# Rezoning Transportation Analysis

Petition Number: 2022-116

Date	Description
12-28-22	First Review (IW)
1-9-2023	Second Review (DR)
11-27-2023	Third Review (NK)

# RZ-2

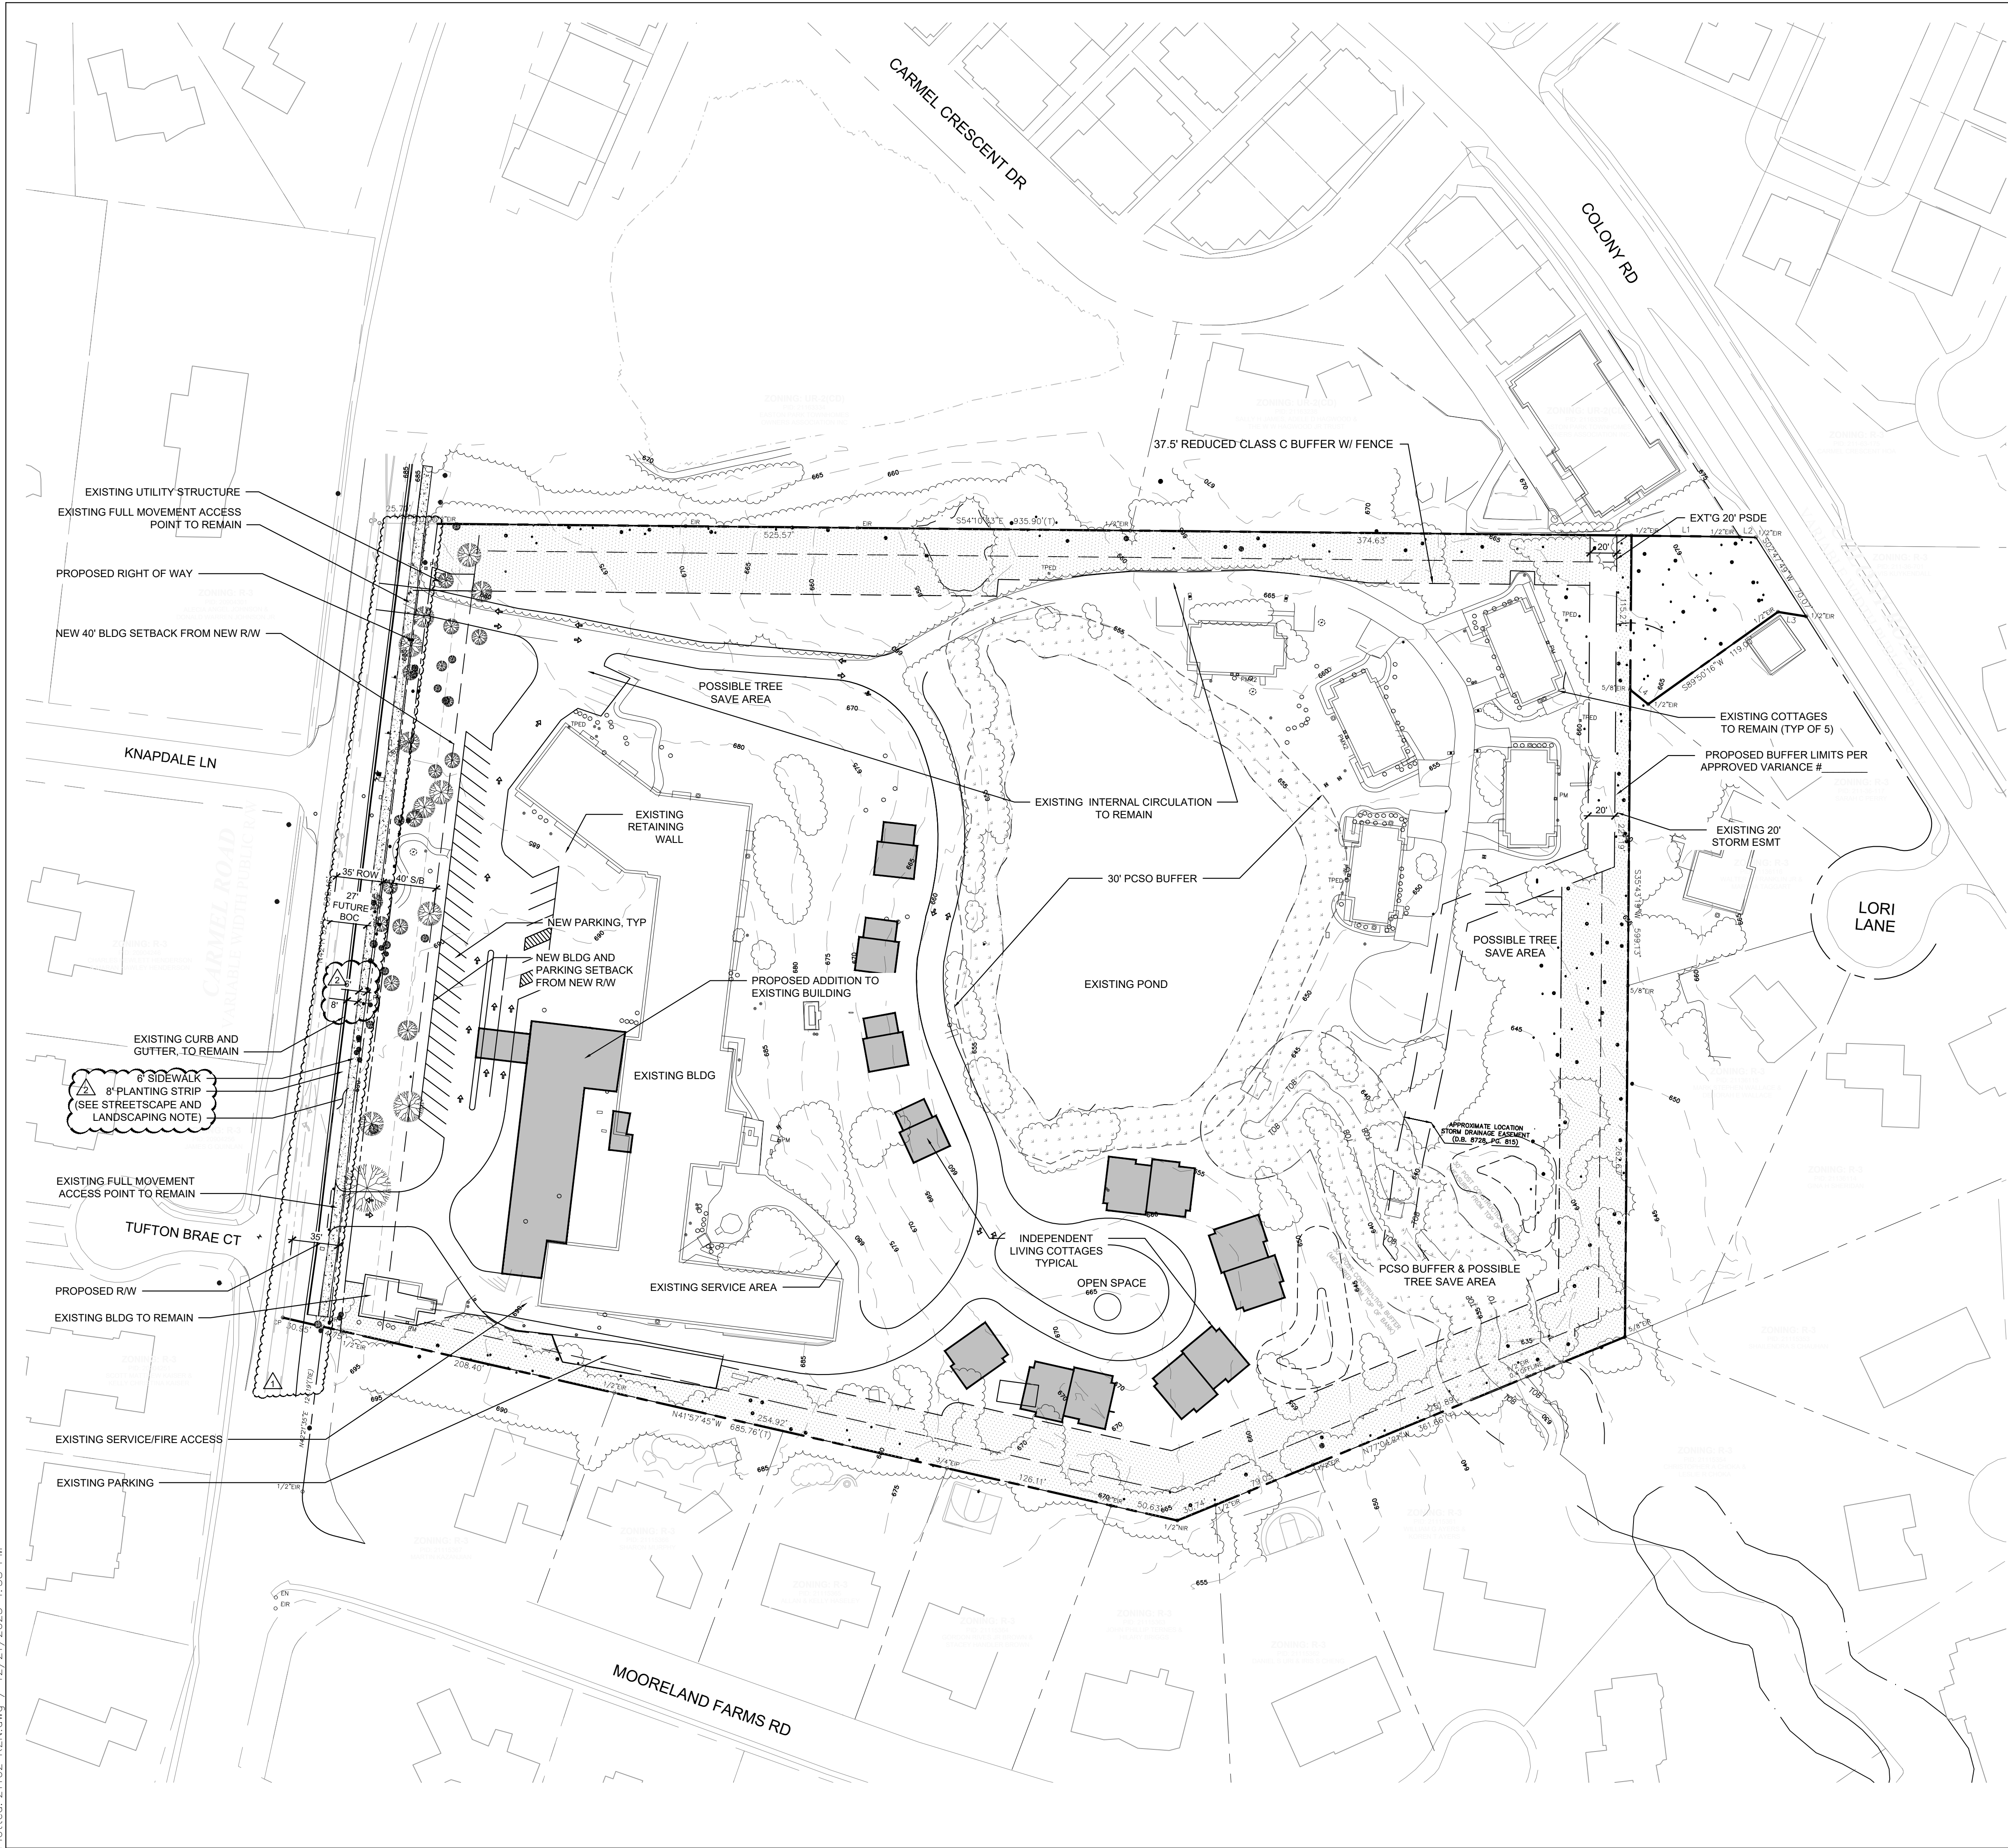
Label and dimension the curb and gutter from the centerline for each road on the site plan.

3. Revise site plan and conditional note(s) to commit to dedicate 43 feet of right-of-way from the Carmel road centerline and 40 feet of right of way form the Colony Road centerline. The site plan shall label and dimension the right-of-way from the road centerline.

**Additional Comment 11/27/23** – Carmel Road needs to be labeled and include that it’s a public road.

Per Chapter 19 revise site plan and conditional note(s) to commit to construct an 8-foot planting strip, and 6-foot sidewalk on Carmel Road and Colony Road.

**Clarifying Comment 11/27/23** – According to Chapter 19, there needs to be an 8-foot planting strip instead of the sidewalk located at the BOC as shown along Carmel Road and Colony Road.

4. Request to revise site plan and conditional note(s) to commit to construct a buffered bicycle facility along Carmel Road by locating the back of curb and gutter 27' from the center line to meet the Council-adopted Charlotte BIKES Policy.

8. Add a conditional note specifying "All transportation improvements will be approved and constructed before the site's first building certificate of occupancy is issued. The petitioner may phase transportation improvements if said improvements and phasing are explicitly described in site plan notes."
